CITY OF ALBUQUERQUE

June 9, 2017

Re: Weck's Restaurant
10131 Coors Blvd NW
60-Day Temporary Certificate of Occupancy- Transportation Development
Engineer's Stamp dated 10-31-16 (B14D001)
Certification dated 6-7-17

sheet-
C101

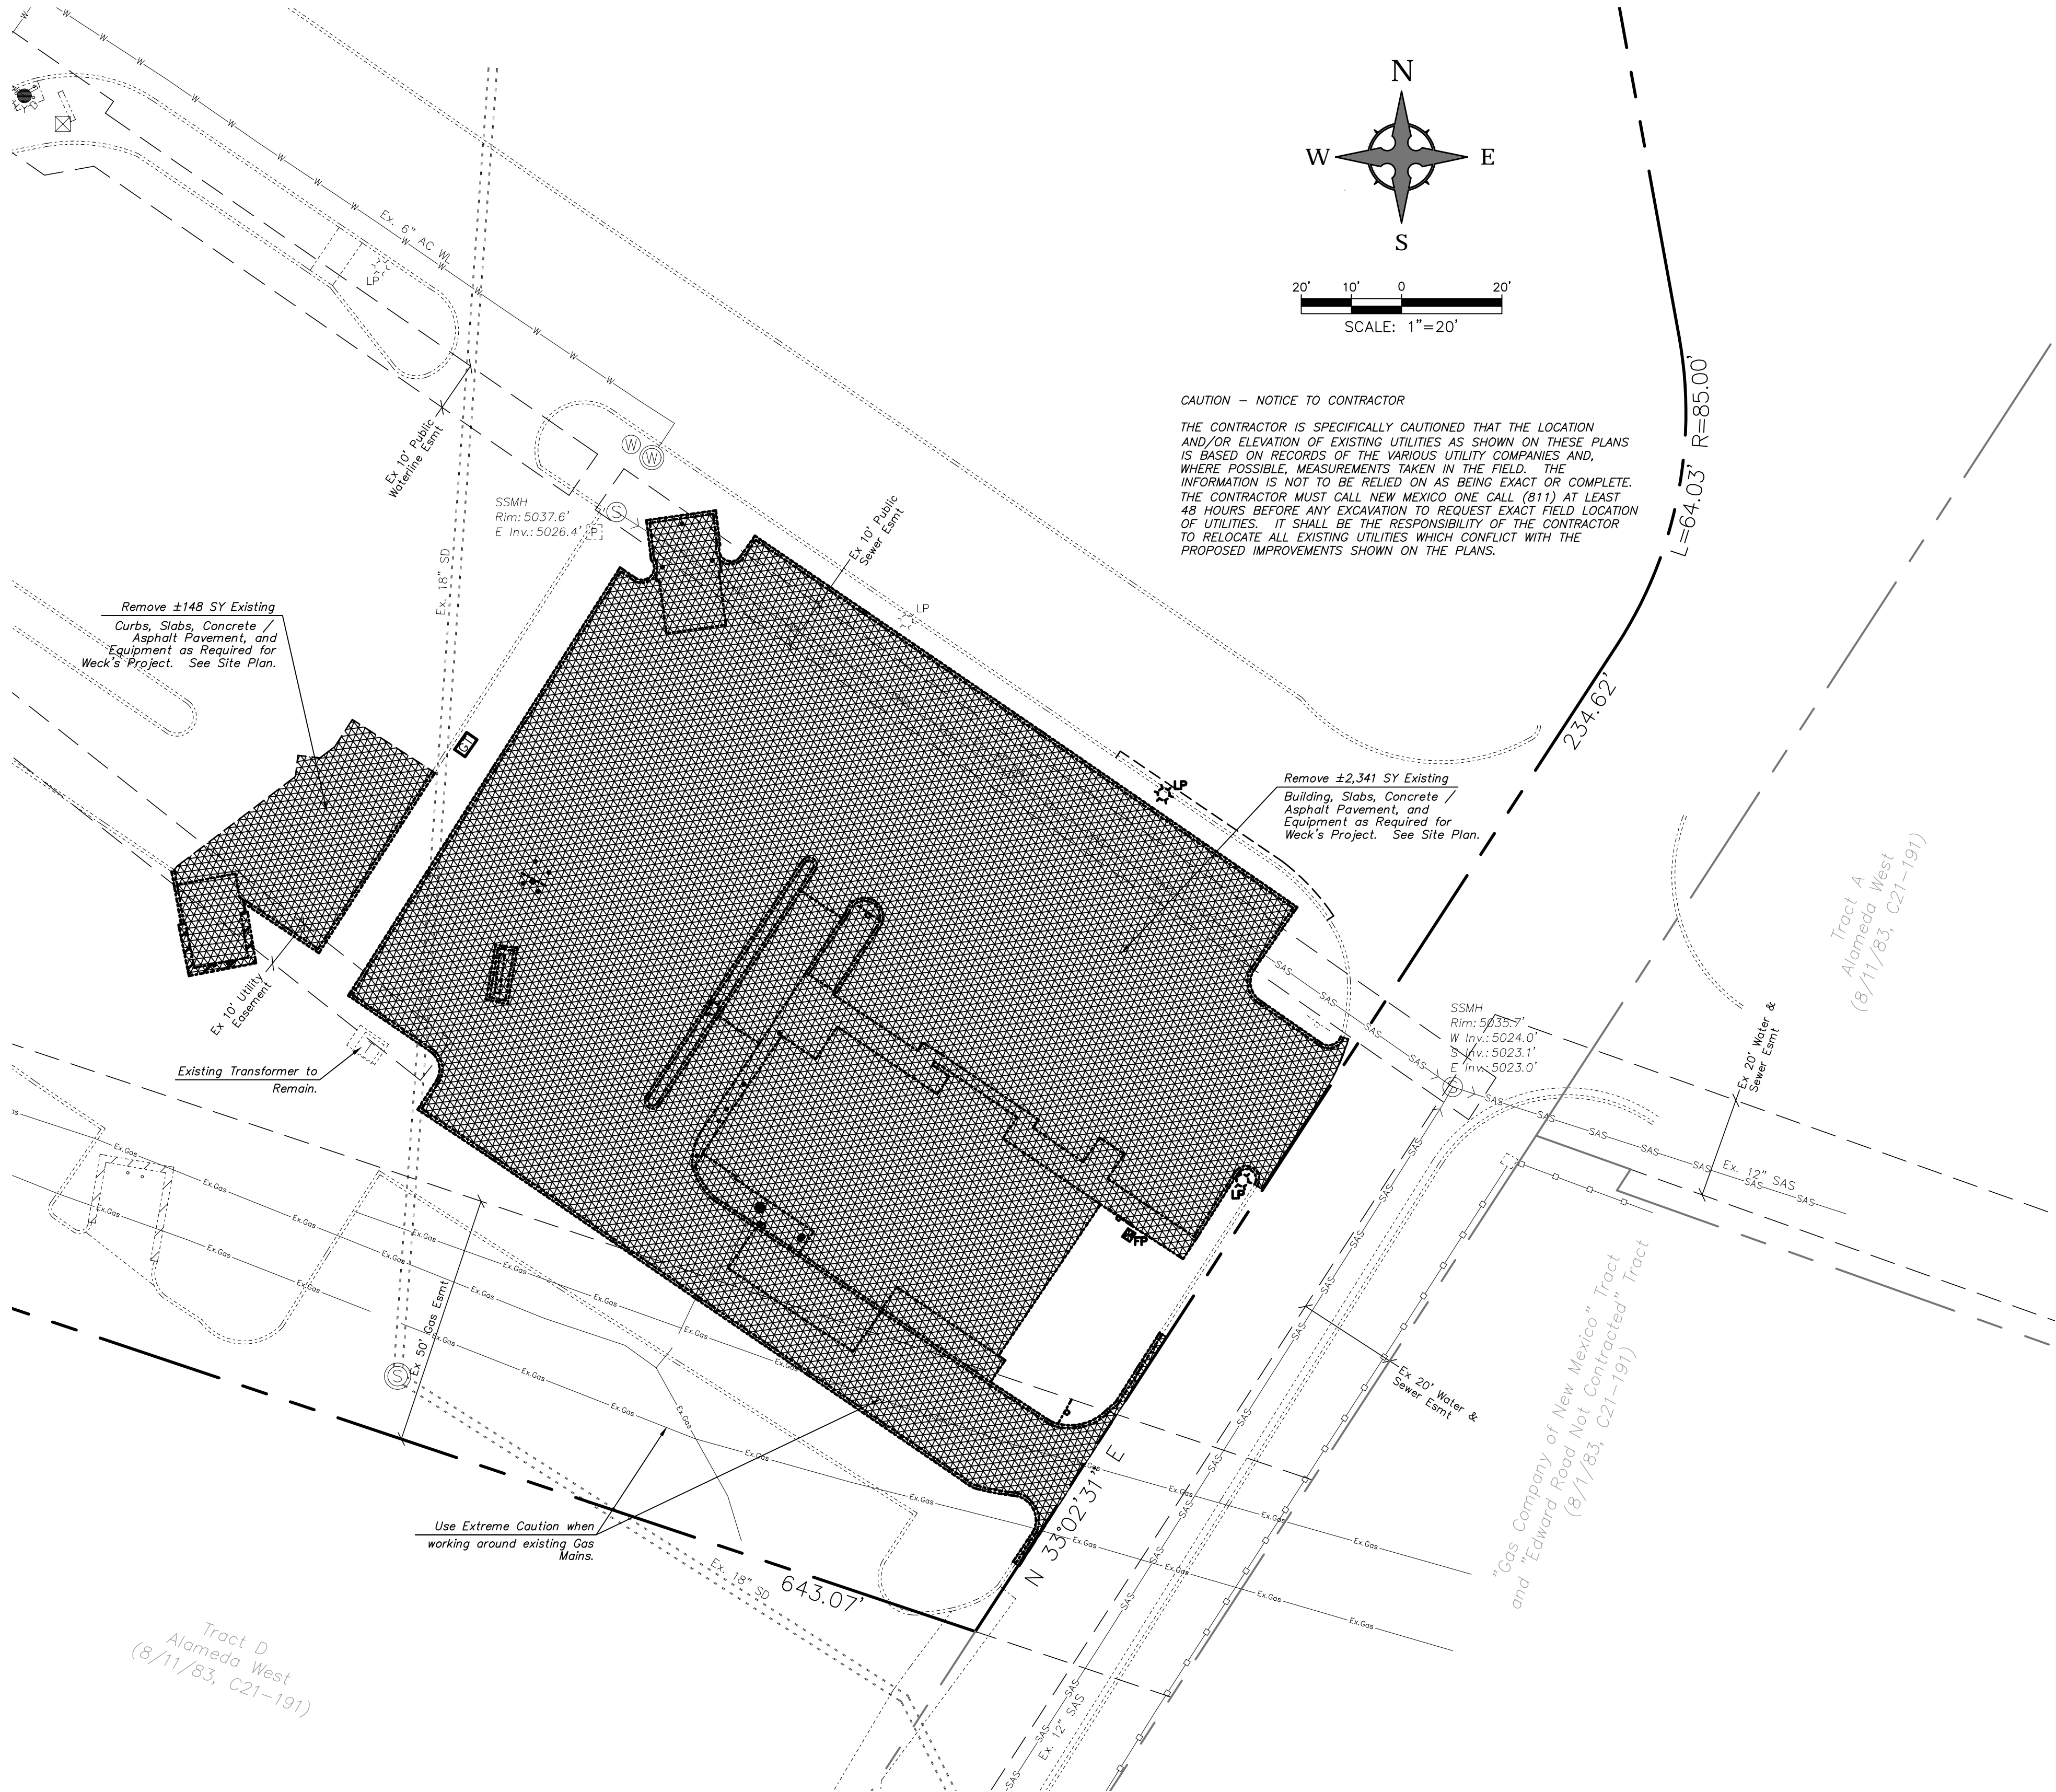
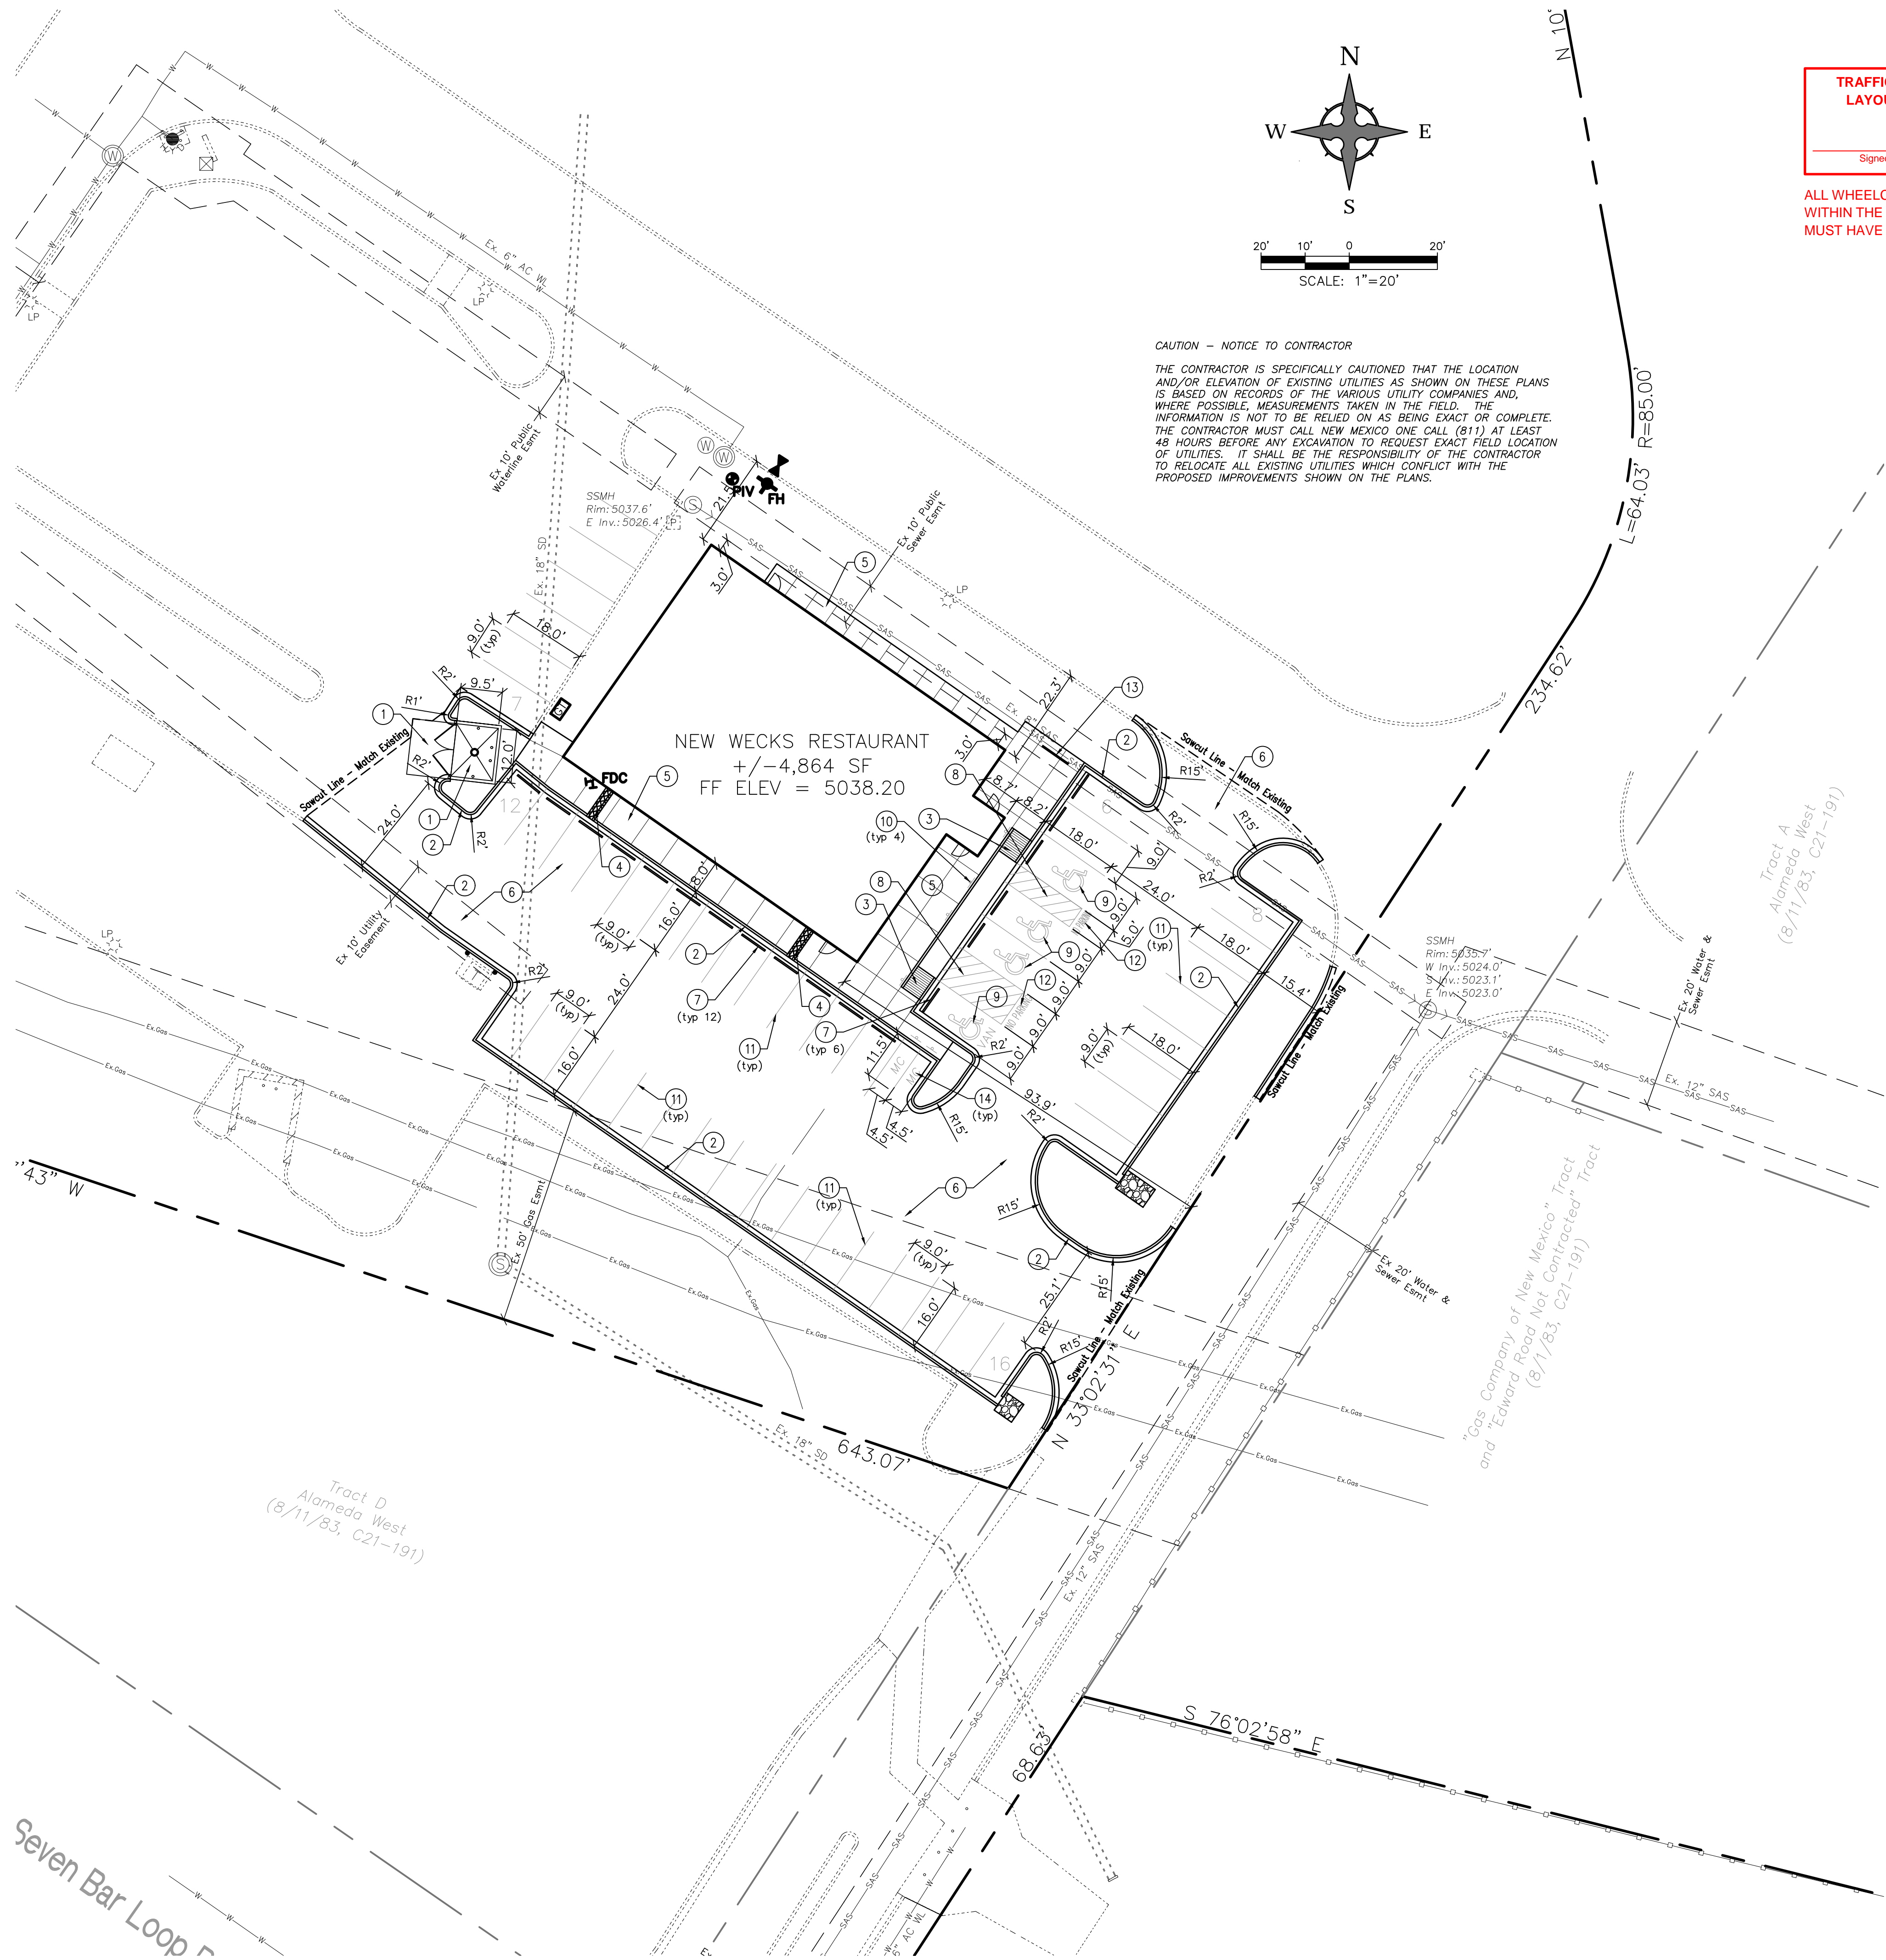
1. Remove all parking bumpers along south west side of the building. Parking spaces should be 18' in length.
2. A stop sign is required at south east exit.
